# Gatwick Airport Northern Runway Project

Statement of Common Ground Between Gatwick Airport Limited and Environment Agency – Clean Version

DATE: JUNE 2024

Application Document Ref: 10.1.12

Figure 4.1: Schematic of Museum Field FCA

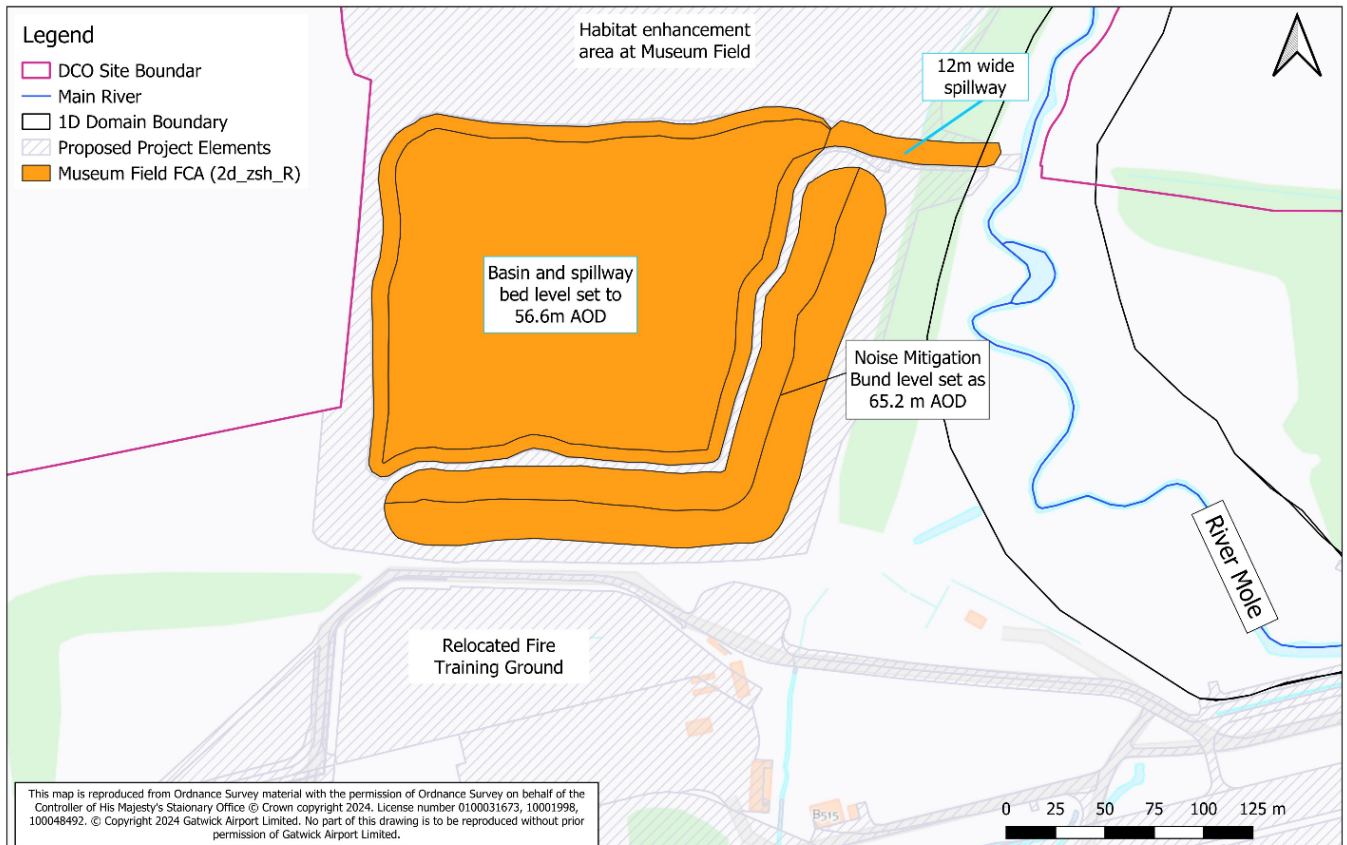
2.8.3.1	Museum field: retaining existing mature habitat where it is compatible with the function of flood compensation area	There are existing mature trees situated within in the Museum Field, which were discussed in a previous joint consultation meeting whether these might be retained and could be assessed for compatibility with the function of that flood compensation feature.  The landscaping plans refers to a clear space with new grassland being created within the flood compensation area and note the landscaping design approach which will test the suitability of existing habitat features for incorporation and retention. However, it remains unclear about the fate of these trees within the Museum field flood compensation area, and therefore request clarification.  The approach is welcome with established river corridor habitat structures and commitments to protect these sensitive receptors from light pollution at all phases of development.	The flood compensation area has been sized and designed to ensure that the majority of trees that surround the area are retained. The only exception will be a small section on the eastern boundary to facilitate connection to the River Mole. An Arboriculture Impact Assessment and Tree Protection Plan are being produced and will be shared once available.		Agreed
